DOC21/1117696-4

Luddenham Advanced Resource Recovery Centre – SSD-10446 – 275 Adams Road, Luddenham

Thank you for the request for advice from Public Authority Consultation (**PAE-33630713**), requesting the review by the NSW Environment Protection Authority (**EPA**) of the Submissions Report for the proposed Luddenham Resource Recovery Facility (**SSD-10446**) at 275 Adams Road, Luddenham (**the Premises**).

Figure 4.1 Water management system layout

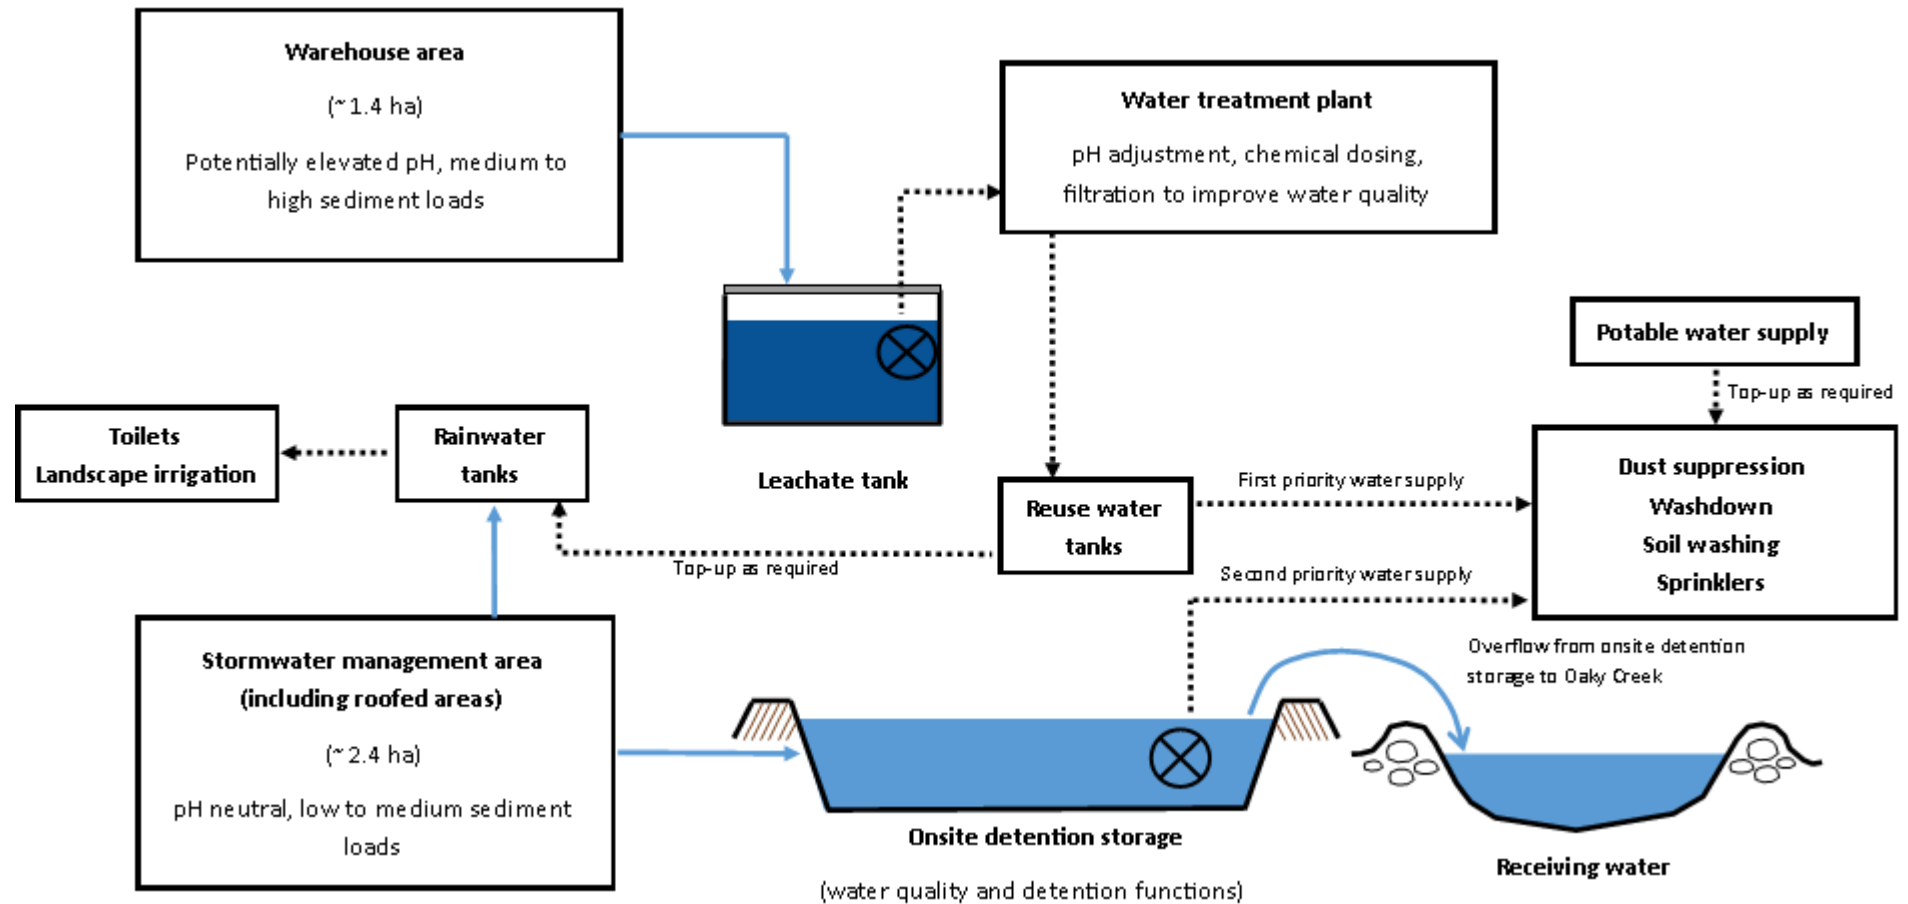
Leachate from within the warehouse will drain to the Leachate Tank (130KL). Contaminated water within the Leachate Tank will be directed to the Water Treatment Plant, and then stored within the Reuse Water Tank (100KL) prior to reuse onsite. The maximum treatment

rate of the Water Treatment Plant is 6L/sec. The EIS has not demonstrated that there is enough holding capacity in the leachate and water reuse tanks. There are no contingency measures if the treatment plant is offline, operating at a reduced efficiency or unable to treat water to the appropriate quality for the nominated end-uses.

The EPA recommends that as a condition of approval the Proponent:

- ***develops a Leachate Management Plan that includes contingency measures if the treatment plant is offline or unable to treat water to the appropriate quality for the nominated end-uses***
